**re: Grading and Site Servicing Plan Review**  
**Proposed Commercial Development**  
3700 Twin Falls Place, Block 2 – Ottawa, Ontario

**date:** April 7, 2025

**file:** PG7255-MEMO.01

LEGEND

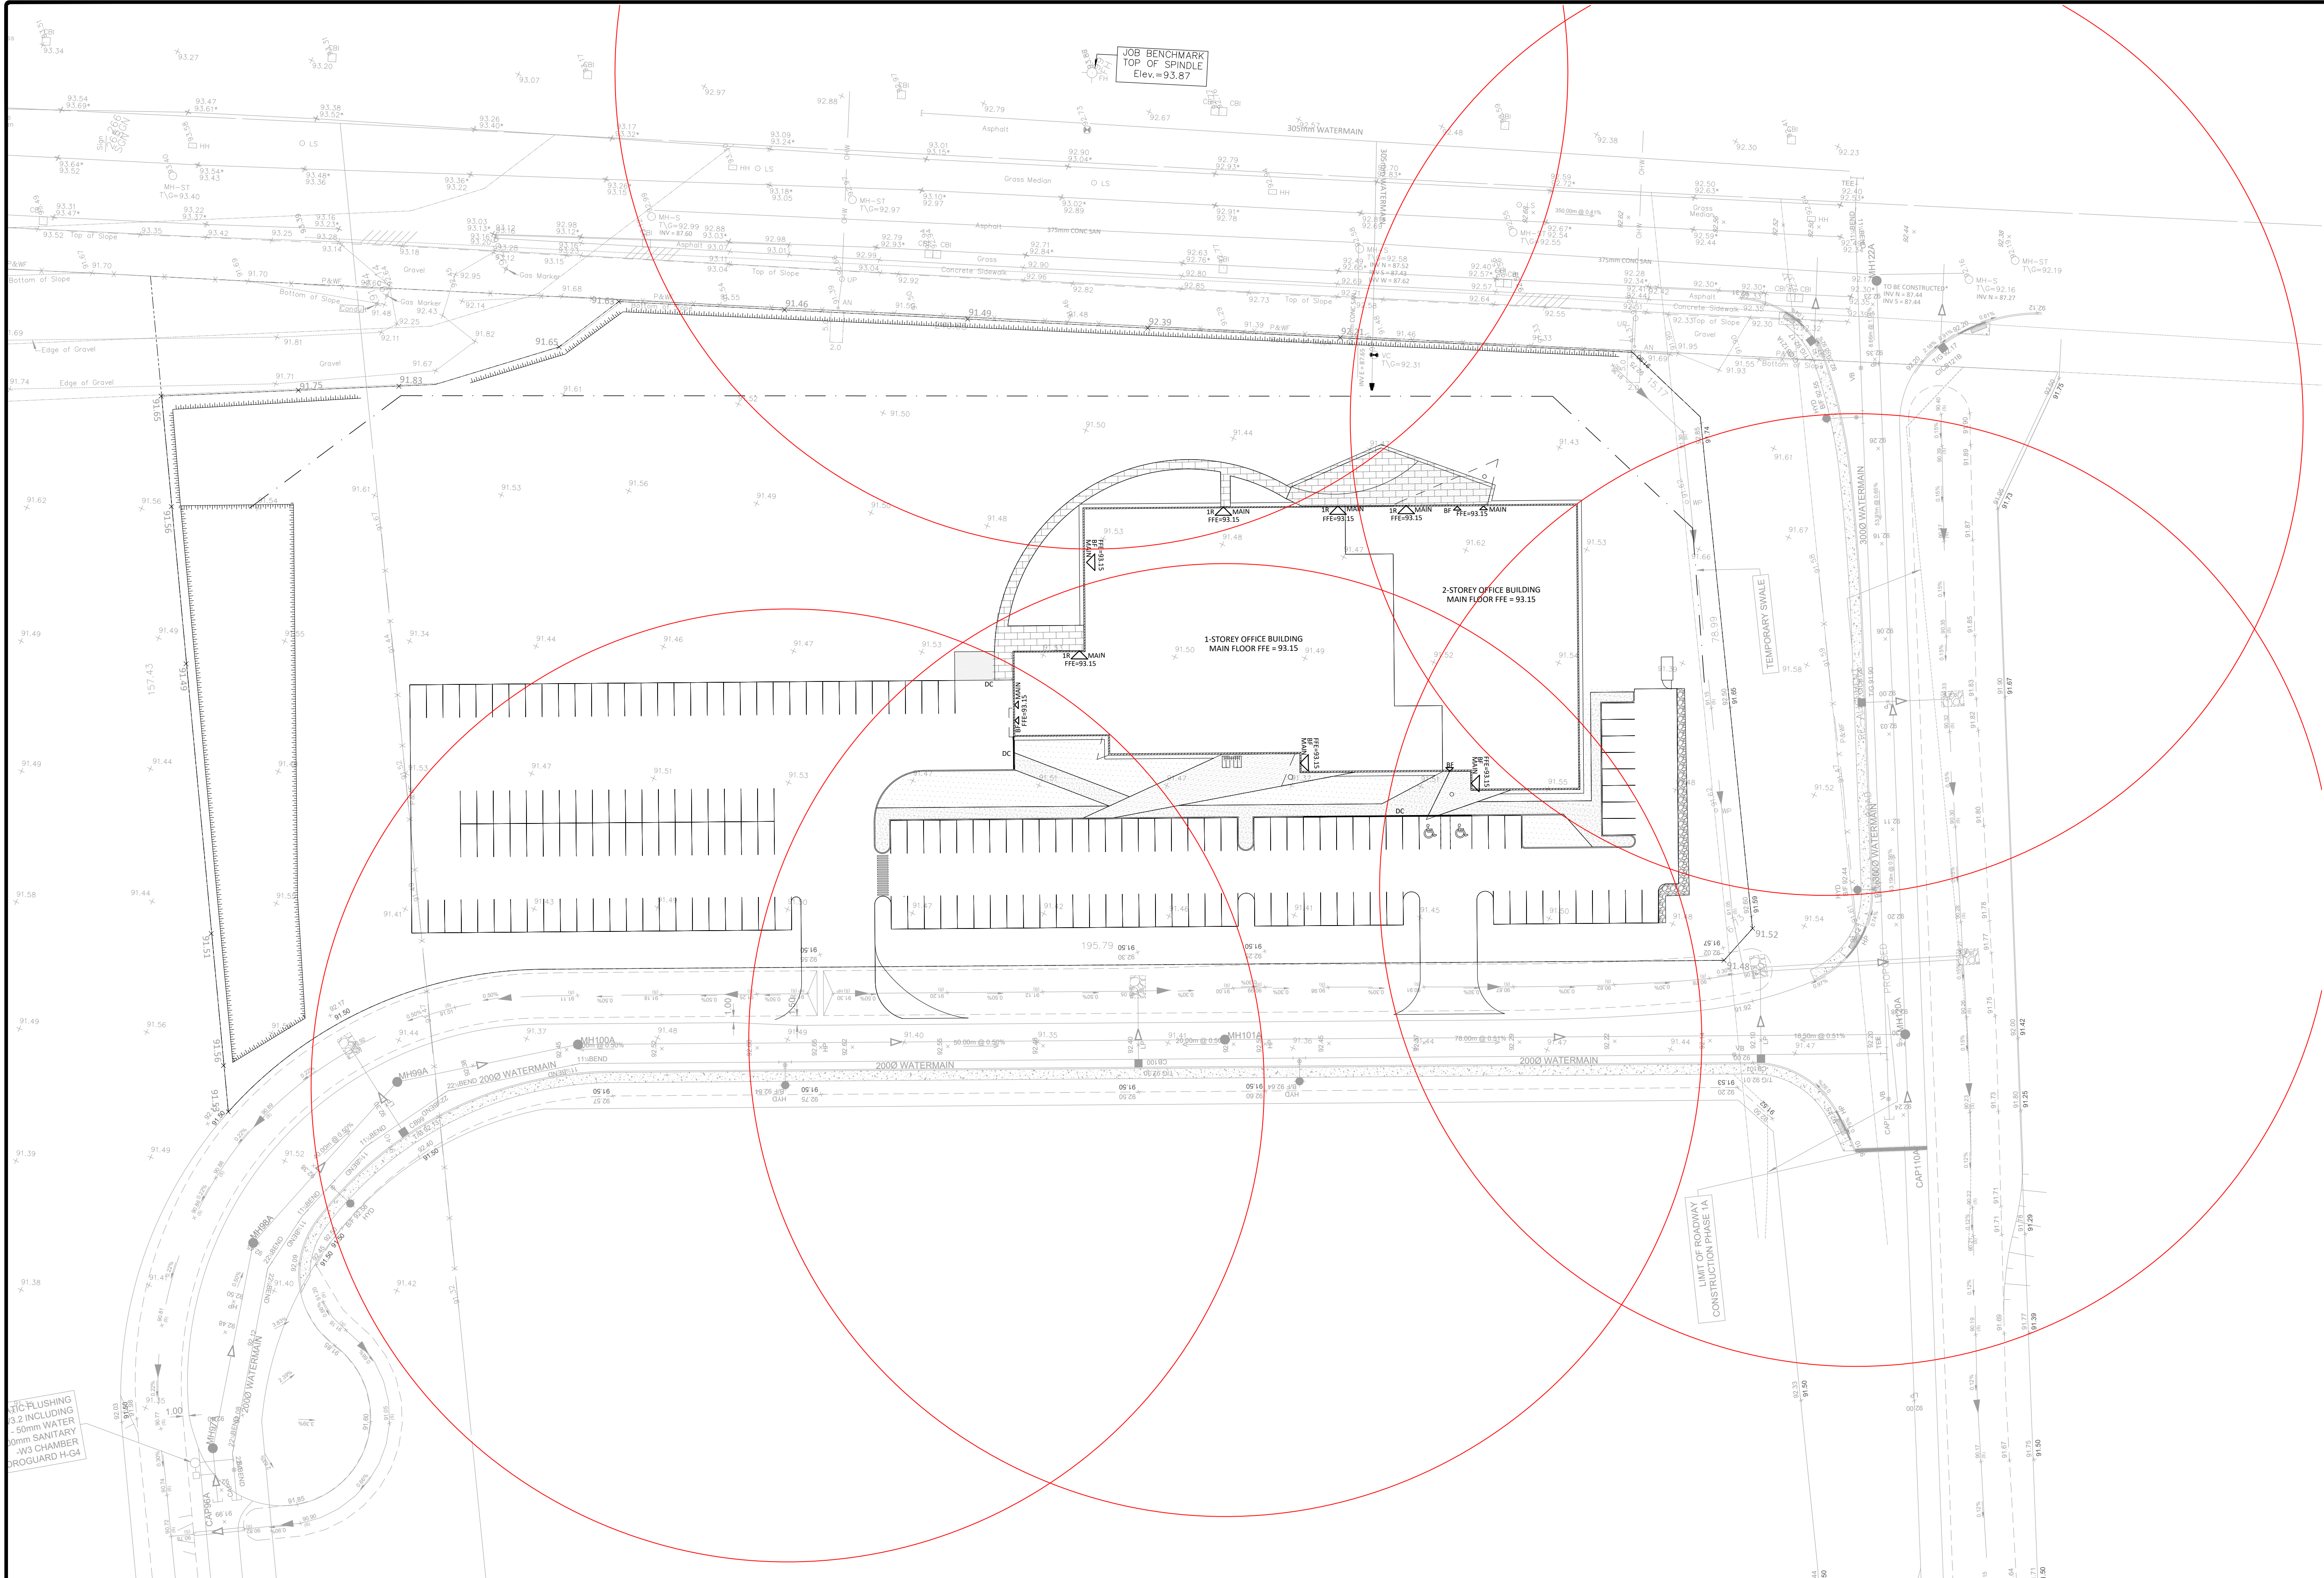
Based on our review of the above-noted site service plan, when assuming an approximate USF depth of 1.5 m, it should be noted that all services will be constructed outside the lateral zones of the proposed footings of the building and are considered to be acceptable from a geotechnical perspective. However, insufficient frost protection has been provided for the proposed storm and sanitary sewer pipes as well as the proposed culvert structures throughout the subject site. It should be noted that the elevation for the proposed connection to the existing watermain pipe was not available on the above-mentioned drawing. The watermain connection elevation should be reviewed by Paterson when available.

Reference should be made to Figure 1 – Markup Site Servicing Plan for the Location of Pipes and Culverts Where Insulation Will Be Required, attached to this memorandum.

It should be noted that the aforementioned storm and sanitary sewer pipes are located within the frost zone, which is 2.1 m below the finished grade. In the following section, frost protection of the site servicing is recommended where insufficient frost cover has been provided.

In addition, it should be noted that based on the invert elevation of the proposed culvert at the southwest side of the subject site and the proposed ground surface at this location, insufficient soil cover (less than 2.1 m) is provided for the culvert structure. Therefore, a minimum 75 mm thick layer of HI-40 rigid insulation or an approved equivalent should be placed directly above the native subgrade prior to the placement of the concrete culvert structure. The rigid insulation should extend a minimum of 600 mm horizontally beyond the edge of the culvert on all sides. The insulation should be placed flat and level over the subgrade with no gaps between sheets. The insulation placement should be reviewed in the field by Paterson at the time of placement.

Any portion of the services installed at a depth of 2.1 m below the finished grade or deeper are considered to have sufficient soil cover for frost protection. Where insufficient soil cover is present above the invert of storm and sanitary sewer pipes, the following frost protection criteria should be followed:

All rigid insulation should consist of either Dow Chemical High-Load 40 (HI-40), Styro Rail SR.P400, or equivalent approved by Paterson. The placement of all insulation within the service trenches must be reviewed and approved by Paterson personnel at the time of construction. Reference should be made to Figure 2 – Typical Frost Insulation Detail, attached to this memorandum.
